FAO: Planning Department,
Welwyn Hatfield Borough Council

Ref: 6/2021/1791/VAR
Date: 16/11/2021

HISTORIC BUILDINGS AND CONSERVATION ADVICE

RE: *Nyn Manor, Vineyards Road, Northaw, Potters Bar, EN6 4PQ*

JOB No.	2109
DWG No.	PL10H
SCALE	1/100 @A1
DATE	JULY 2019
DRAWN	PH
CLIENT

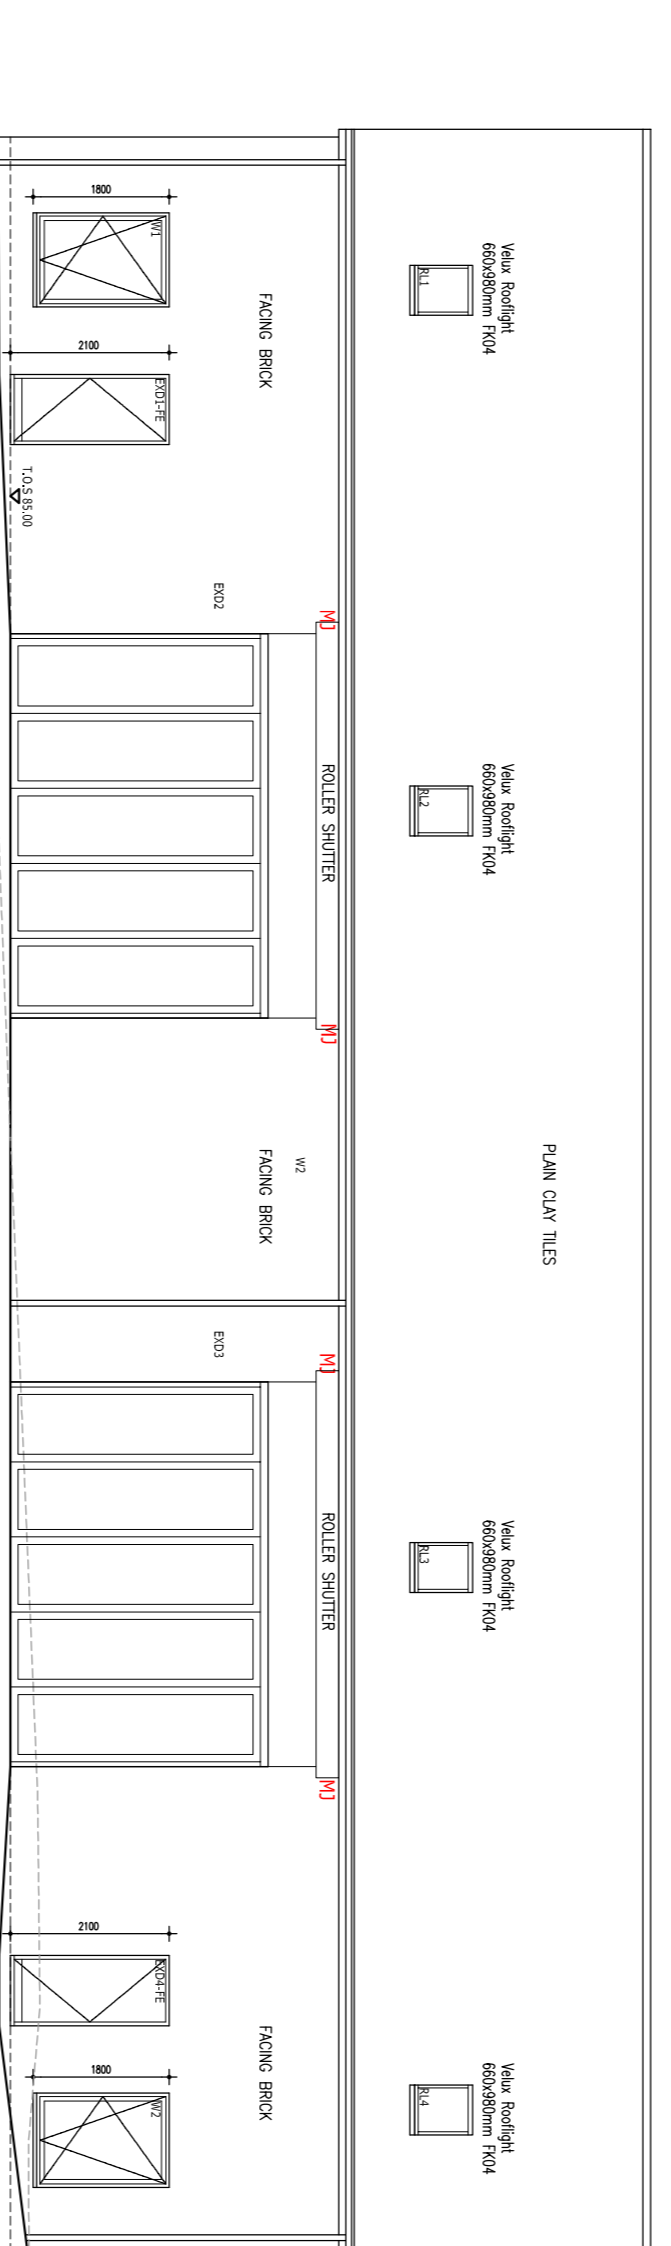
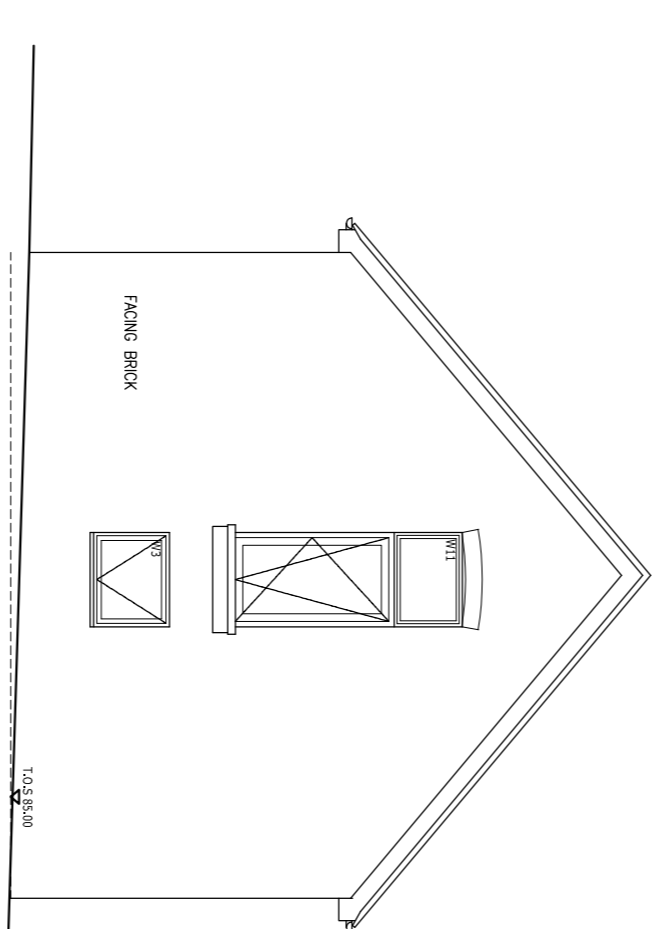
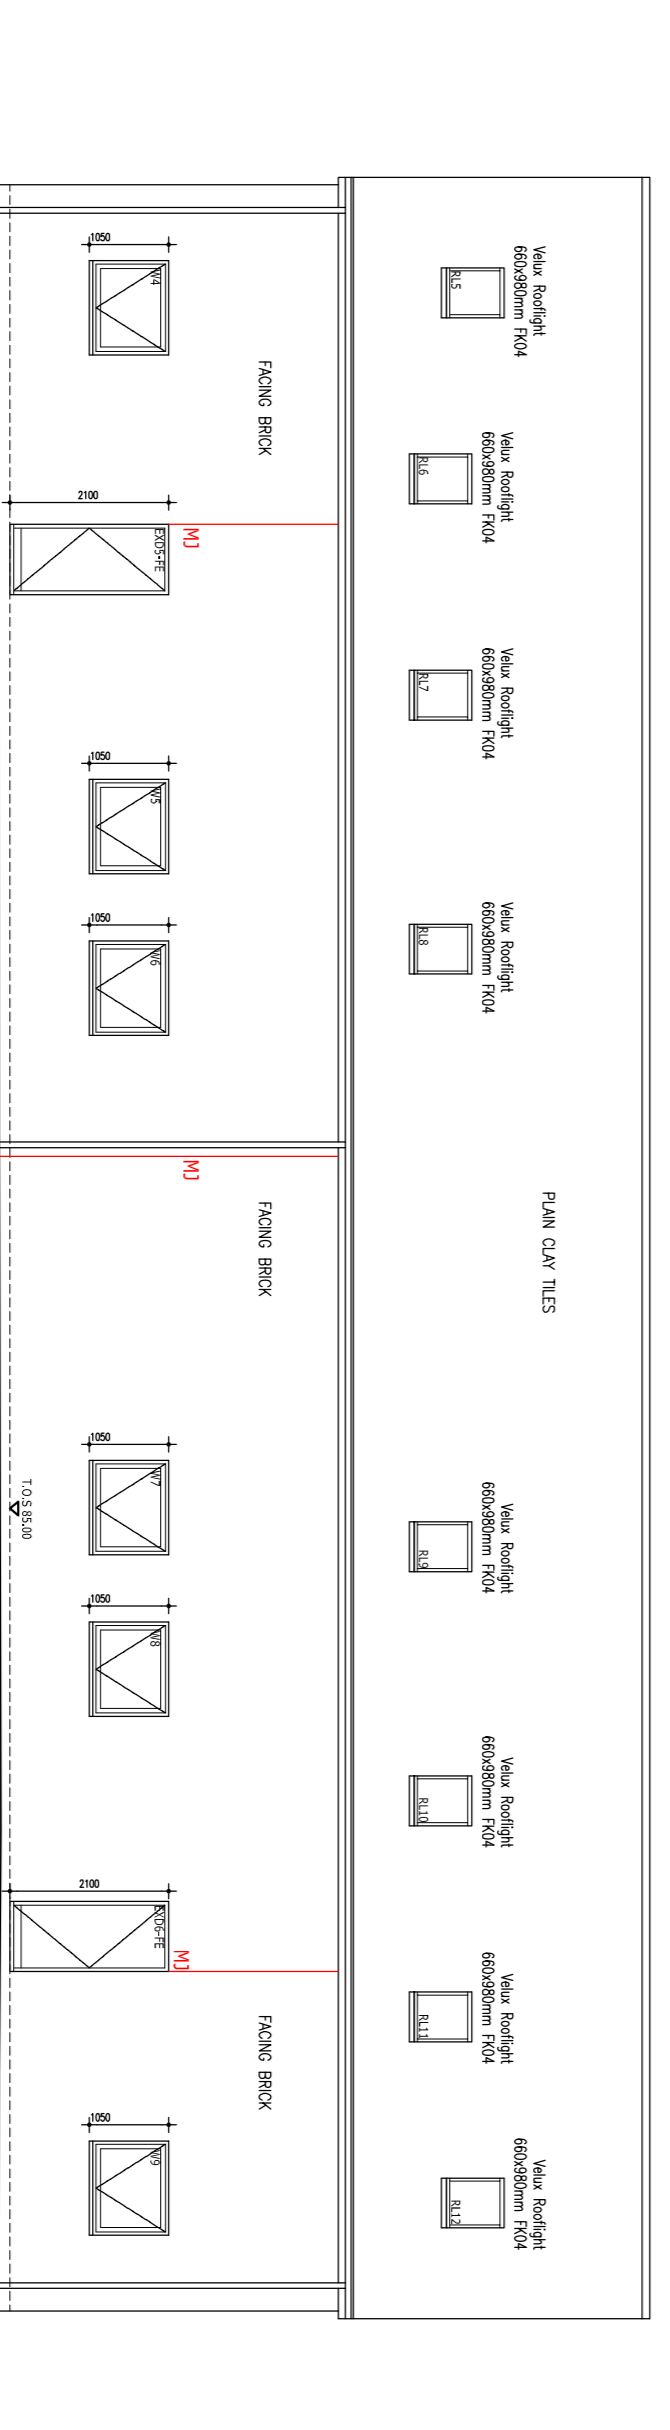
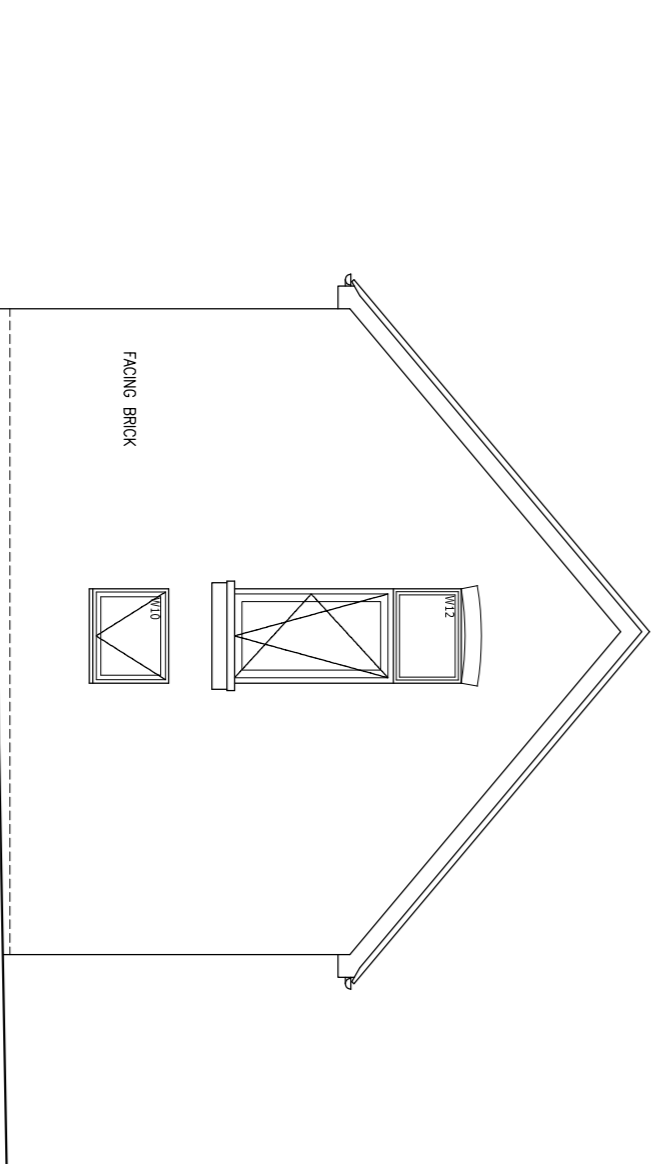
The below comments follow the submission of revised drawings to show the machinery shed 'as built' to include glazed bi-fold doors behind the roller shutters as well as the additional rooflights and other changes.

Concerns were raised in the last consultation letter regarding the number of rooflights. It was considered that they resulted in a cluttered roof slope facing the listed barn, contrasting with the simple, uninterrupted roof of the barn. It was not considered that the rooflights *alone* would result in harm to the significance of the listed buildings. However, the amended drawings show the addition of glazed bi-fold doors behind the roller shutters. These have further altered the appearance of the building by introducing additional fenestration which is more domestic in character, contrasting with its agricultural use and undermining its utilitarian appearance. Similarities in the appearance of the machinery shed and the non-listed barn to the west have been noted in the Planning & Heritage Statement but it is understood that the non-listed barn is in ancillary use to the farmhouse and so has a more domestic appearance.

The cumulative effect of the additional rooflights and the glazed bi-fold doors results in a building with a more domestic appearance which does not relate to the functional character of the farmyard which is an important element of the setting of the group of listed buildings (Nyn Manor Farmhouse, list entry no. 1348169; stables, list entry no. 1295991; and barn and wall, list entry no. 1100976). The changes to the building are considered to result in a low level of 'less than substantial' harm to the significance of the listed buildings due to inappropriate development within their settings.
